# **KITITAS COUNTY**

### **MEMORANDUM**

SUBJECT: Forest Ridge Final Plat Resubmittal LPF-20-00005

FOREST RIDGE - PHASE I PERFORMANCE BASED CLUSTER PLAT		
PREPARED FOR FRPP PHASE I, LLC A PORTION OF SECTION 24, TOWNSHIP 20 NORTH, RANGE 15 EAST, W.M.		
KITITAS COUNTY		WASHINGTON
DWN BY T.S.	DATE 01/2021	JOB NO. 18069
CHKD BY M.K.K./D.L.P.	SCALE 1" = 100'	SHEET 5 OF 6

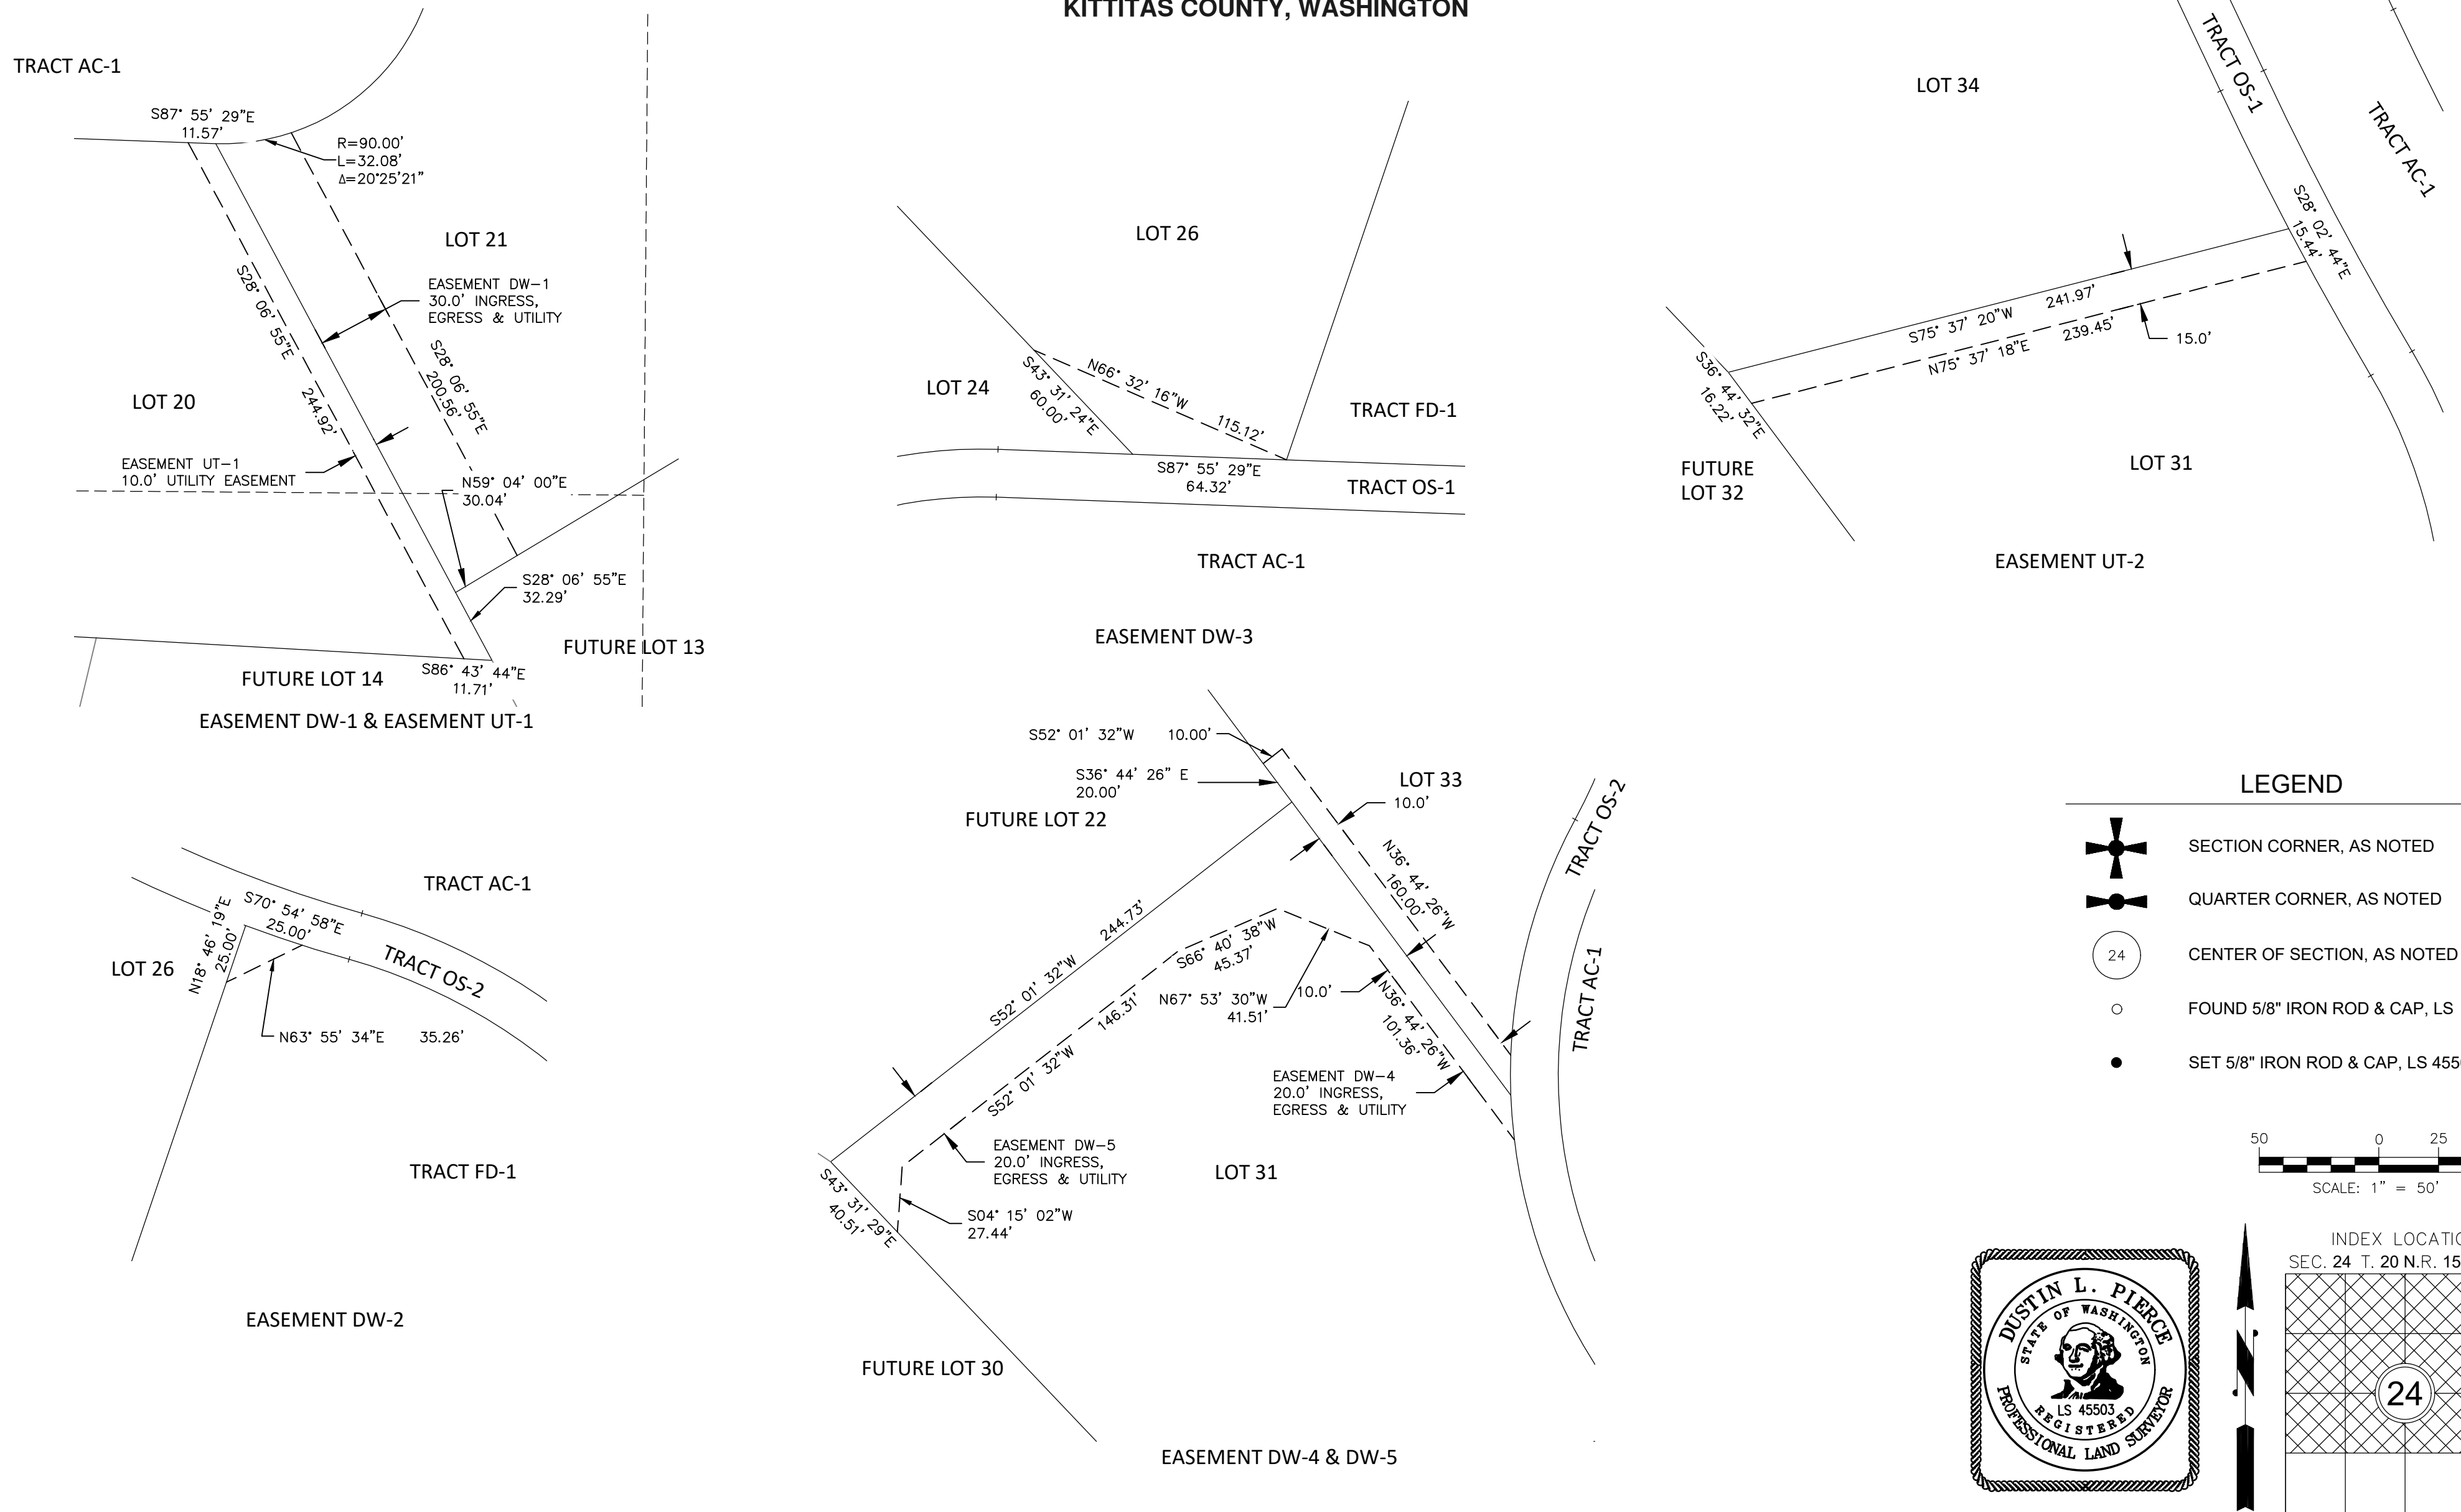
1. Survey Note 3, Sheet 1 shows a blank for the equipment used, and includes a few typos.
2. The N1/4 corner and the E1/4 corner do not have ties to determine the location.
3. Section corners are shown in the legend "as noted". Map contains no such notation.
4. The parcels identified as FD-2, FD-3 and FD-4 do not have any defined limits shown.
5. The historic parcels A-1 through D-2 can be confusing as they are not clearly identified as historic parcels. Including the recording number (AFN or Book and Page) would clarify this.
6. Set corners shall be shown on the face of the plat.
7. References to other pages (See Sheet X of X) are incorrect in the total page count, (all occurrences) as well as the reference page (n'most label, sheet 5)
8. There are multiple occurrences of labels being obscured by crossing linework.

CREEKSIDE ROAD & FOREST RIDGE DRIVE
IRON SNOWSHOE, LLC
CREEKSIDE ROAD
PLAN AND PROFILE

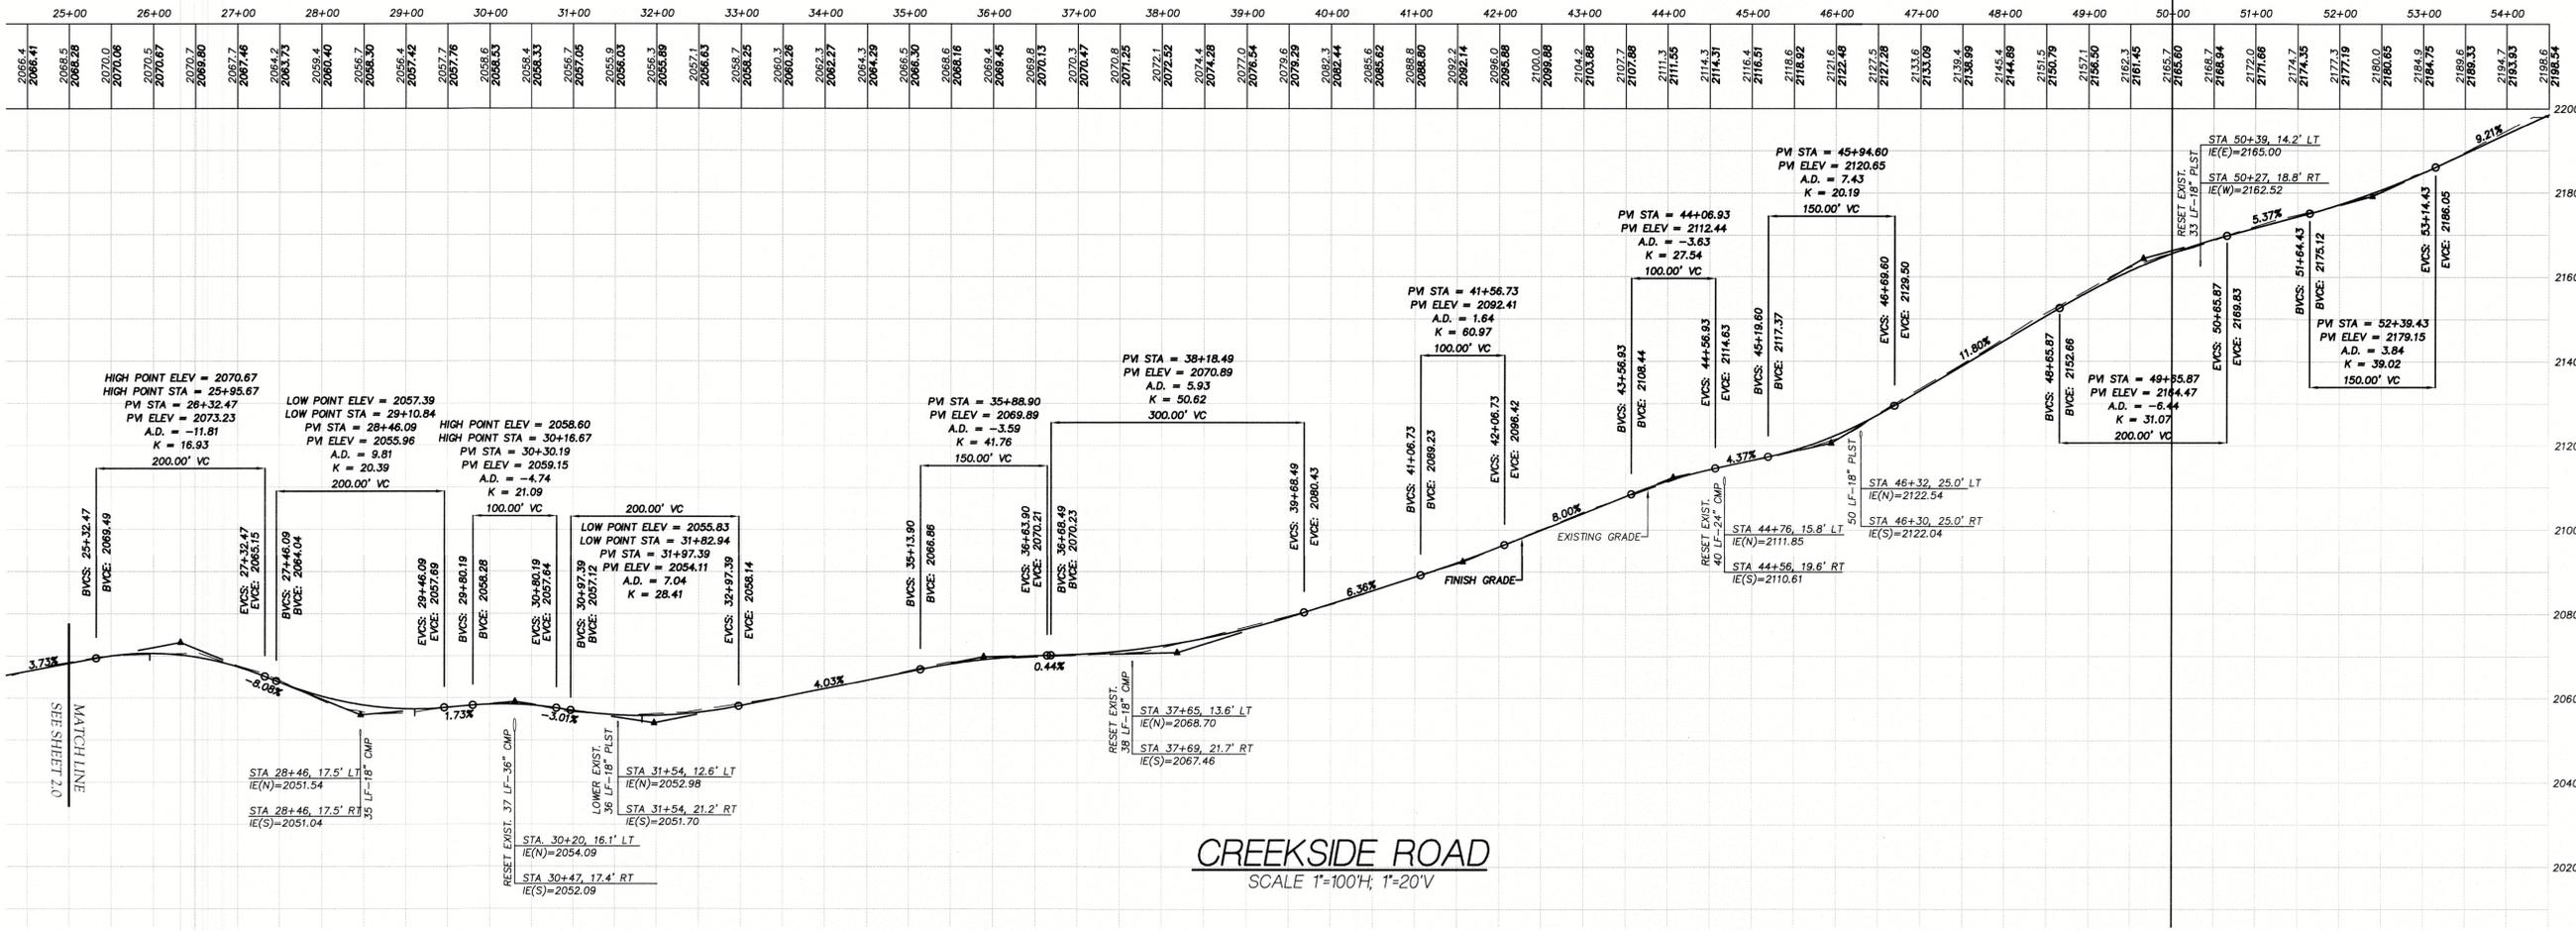
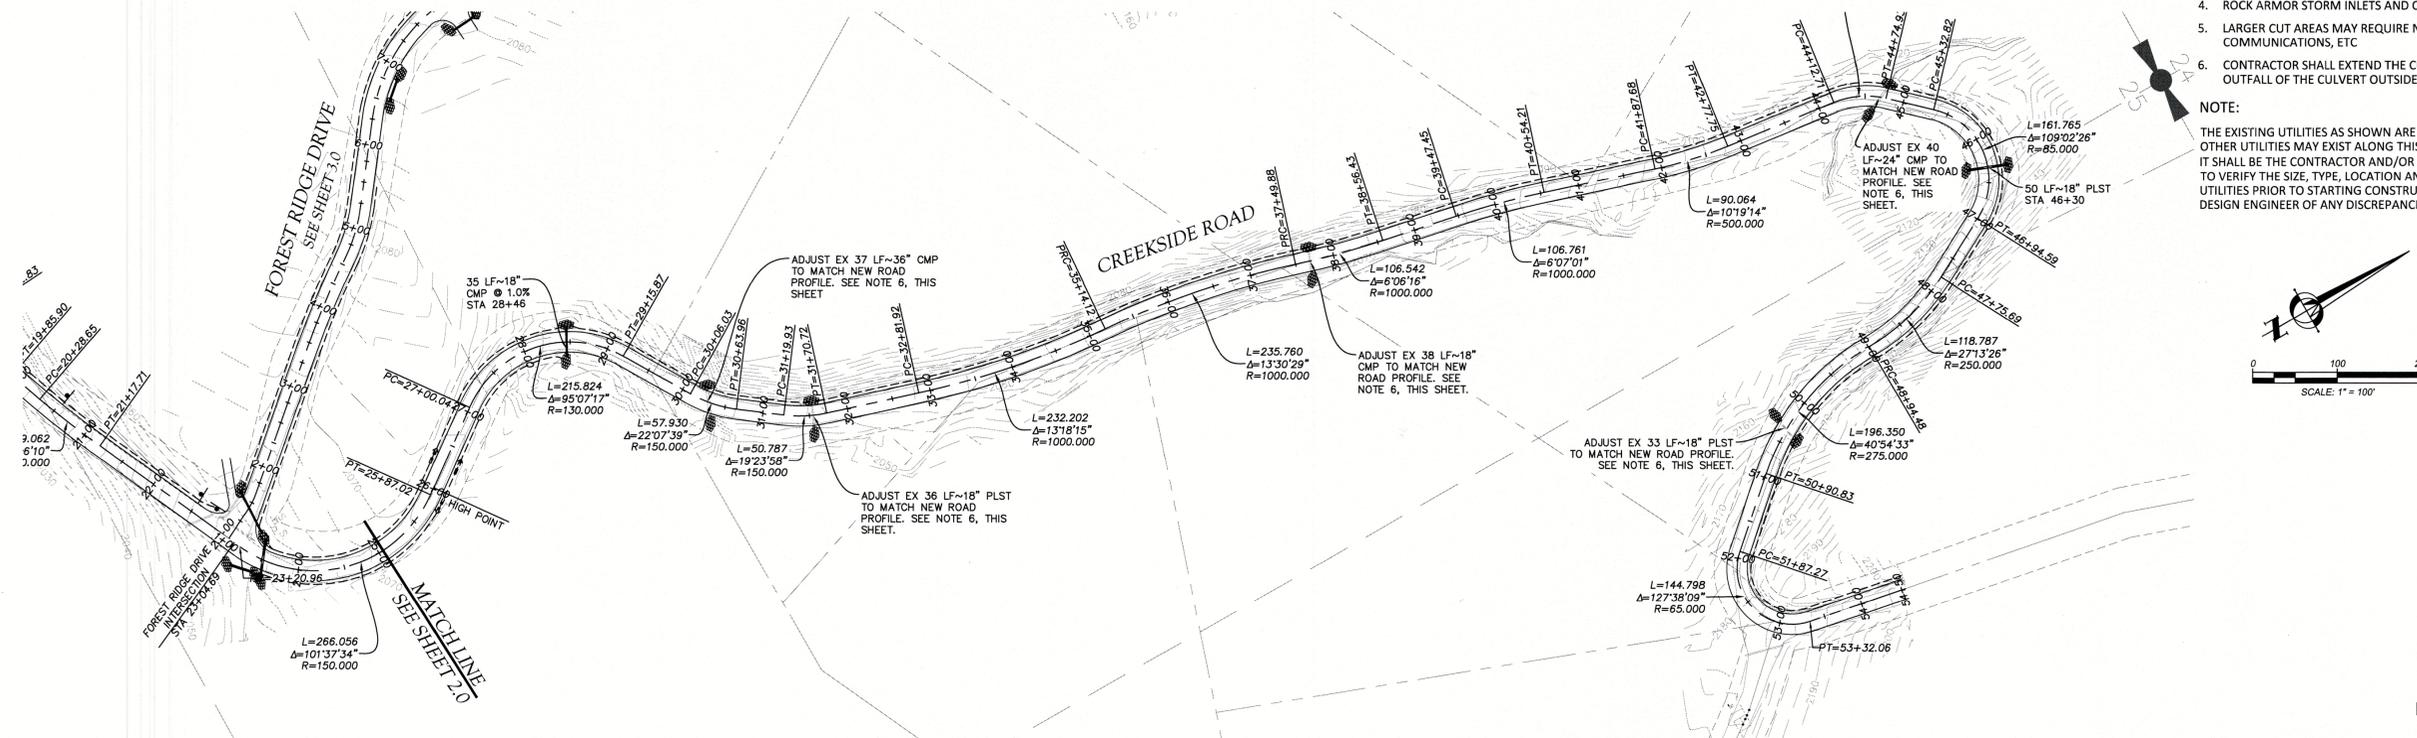
- b. The county was made aware that WDFW is requiring two larger (4ft) culverts which will need to be installed on Creekside Rd at approximately 12+00 and 44+00. These haven't been installed and they aren't shown on any plans, but a change like this will likely require significant changes to the road and surrounding ditches.
